Our Ref: 181099/ml/KBL-01

28 January 2019

JOEL STREET - NORTHWOOD

This letter has been prepared in response to the comments issued by Flood and Management Specialist of Hillingdon Borough Council. The reasons given for objection are the greenfield runoff rates for the existing site, the proposals do not provide detail of the long-term management and maintenance, opportunities for more sustainable drainage have not been explored.

Drawing 181099/500/01 – Drainage Layout

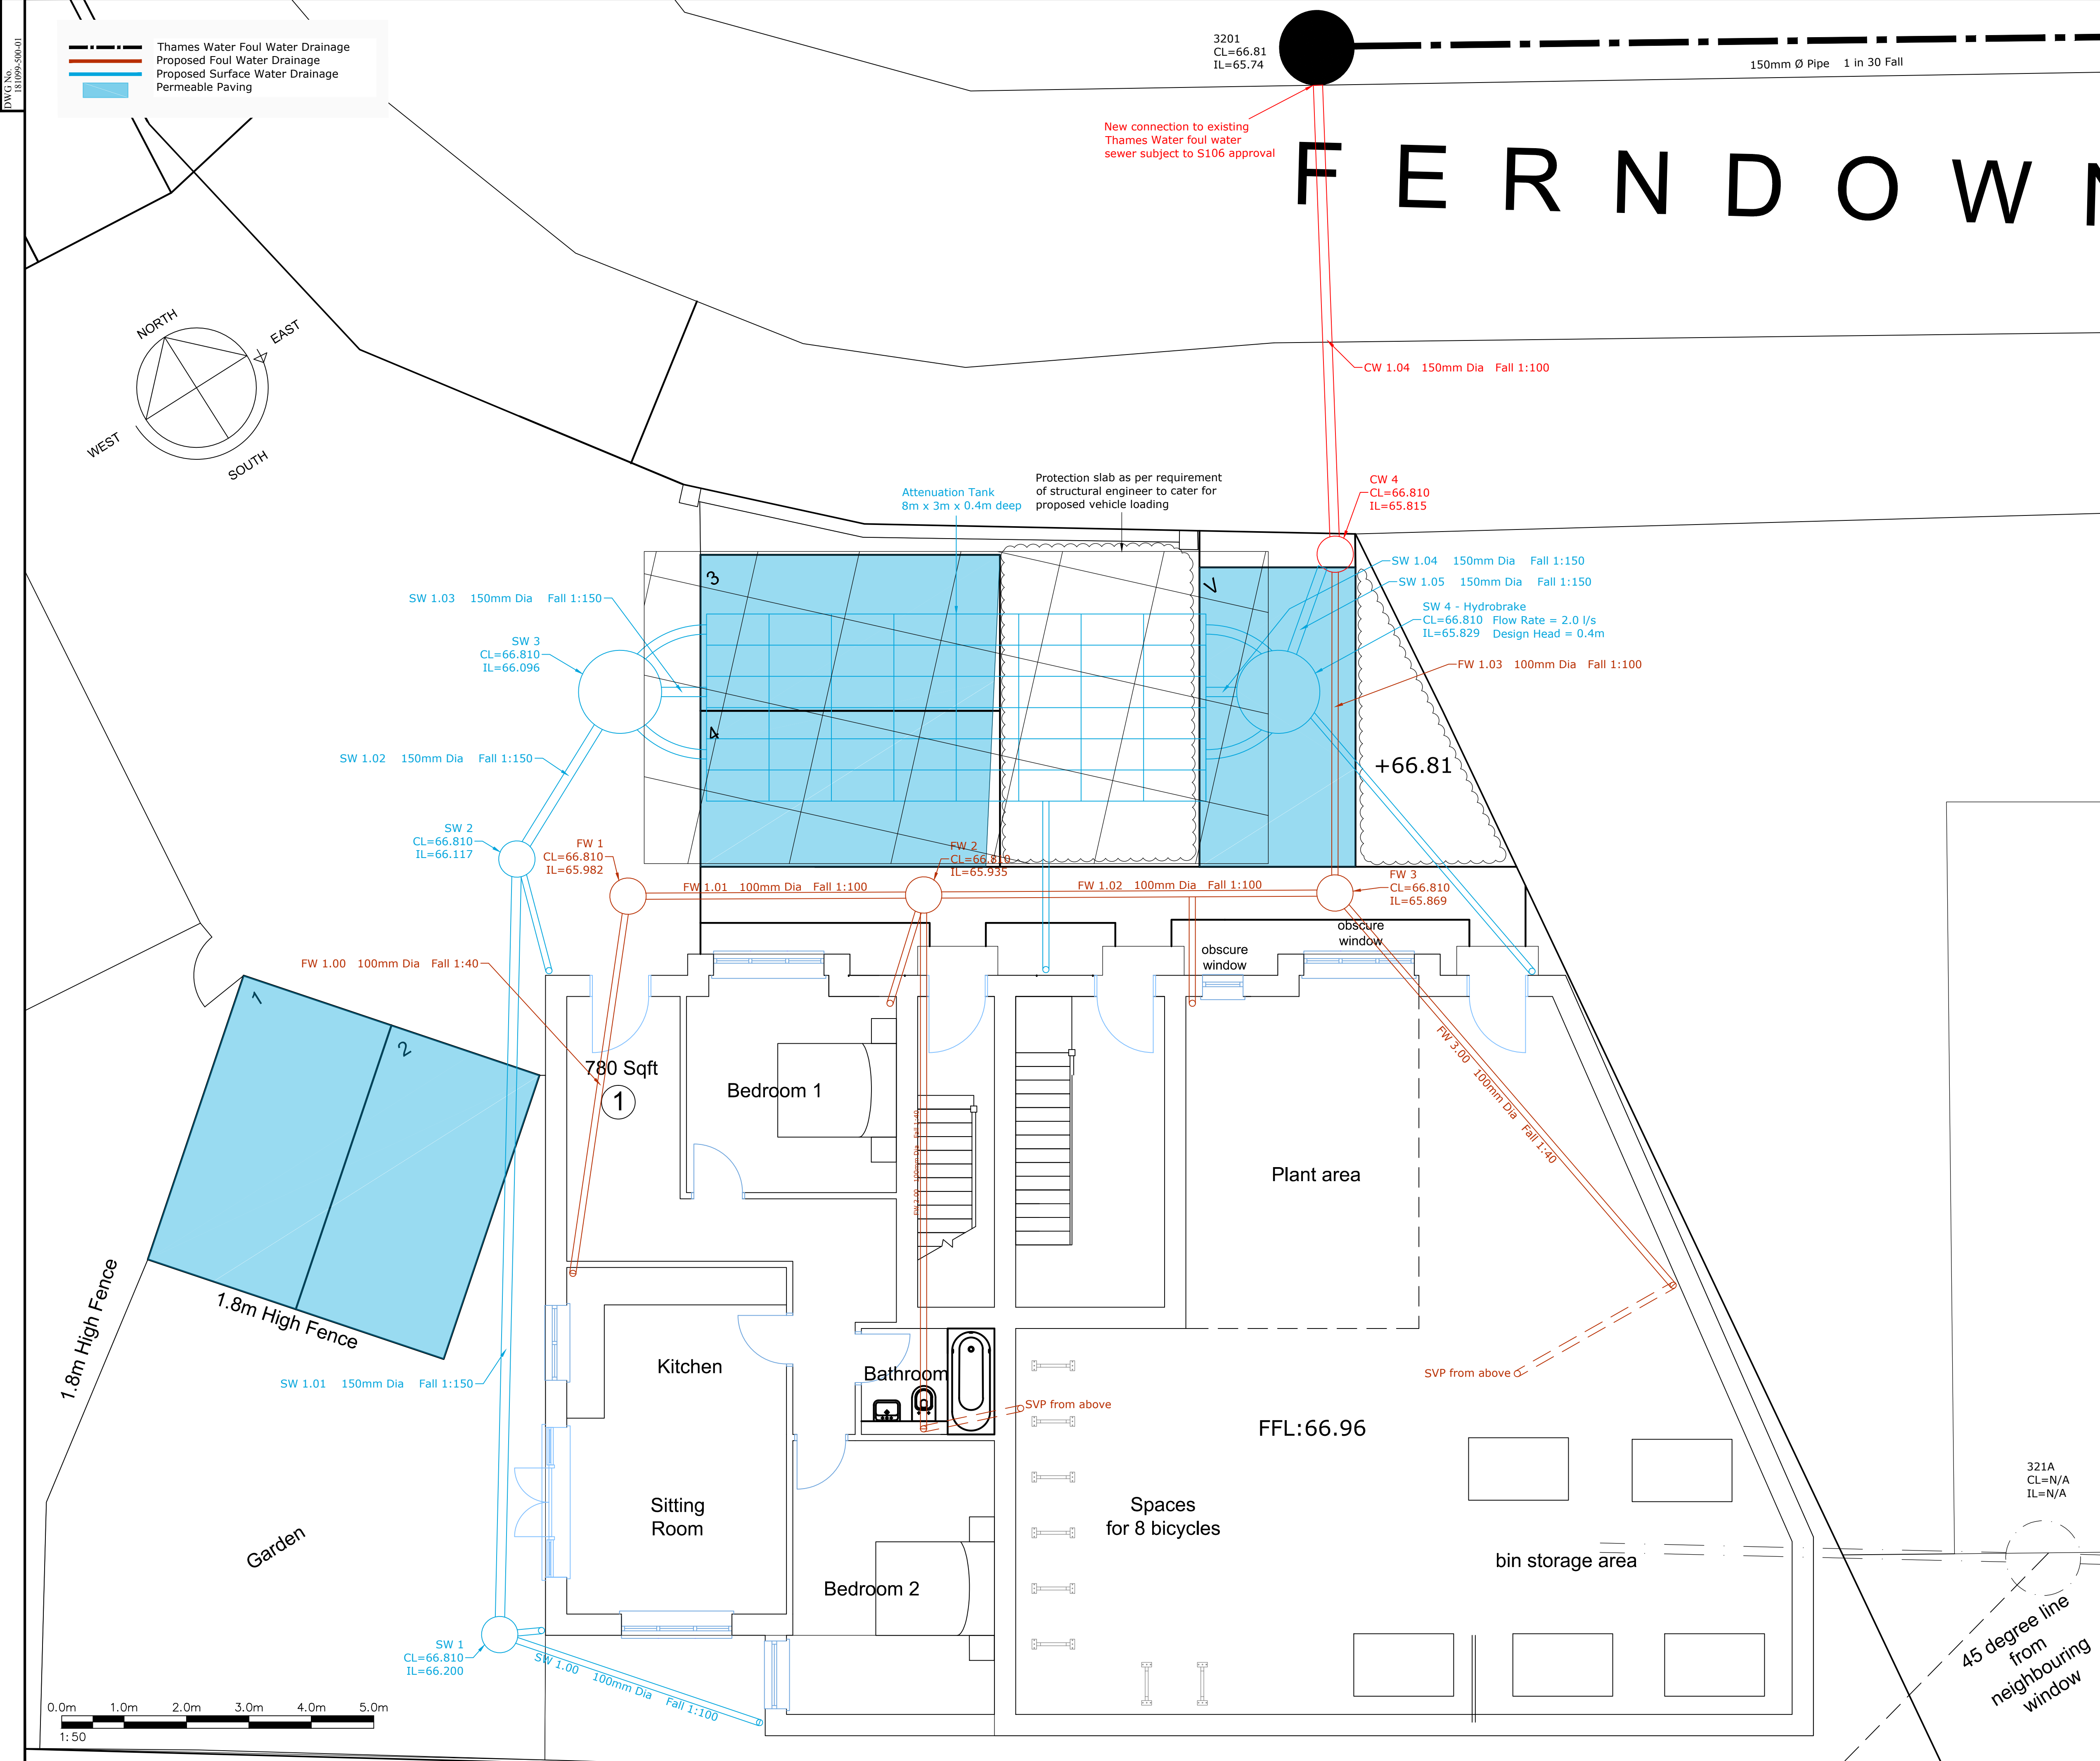
LLFA also question the lack of SuDS and use of underground attenuation. SuDS was considered at the design stage, greenroofs were an option as the roofs are pitched. Rainwater harvesting was discounted on the grounds it would have to serve several properties and the maintenance of it would be complicated and the attenuation benefits provided would be limited. Soakaways were discounted on the grounds of poor soil conditions and also there lack of space, it is not possible to provide the 5m clearance from buildings to the soakaway. The LLFA suggested Rainwater Gardens but these are considered point infiltration devices similar to soakaways, there is not guidance in the UK as to minimum distances required from buildings, but in Australia where they are widely used they recommend a minimum clearance of 5m in clayey soils. Similar to the requirements of the Building Regs for Soakaway. On this basis Rainwater Gardens were discounted on the grounds that is not possible to provide a 5m clearance from the building to the Garden. However the design has been amended to incorporate aboveground Rainwater Planters, these are now indicated on the revised drainage plan 181099/500/01 enclosed.

The LLFA questioned why the permeable paving depth was not increased to provide more attenuation. The reason the permeable paving has been designed to provide minimal storage is due to the site level and outfall. There is only 1m level difference from the finished ground level to the invert level of the outfall from the site. To provide the required storage the cellular crate system needs to be 500mm. This means we are only able to provide 500mm of cover at one end and 400mm at the other end, neither of which is acceptable to accommodate vehicle loading. Therefore, a 200mm thick concrete protection slab will be required over the crates. The surface construction of the parking area will be in the region of 150mm thick and with a separate layer between the slab and base of permeable paving you are only able to achieve a granular sub-base of between 50 to 150mm. To provide a deeper layer of granular sub-base the attenuation tank would have to be lowered and that would mean that a gravity connection to the sewer would not be possible and a pump would be required to discharge runoff from the site. It is for these reasons that the majority of the storage is provided with the attenuation tank, the permeable paving to the front of the site will provide some storage but the worst case has been assumed for sizing the attenuation tank that this is limited.
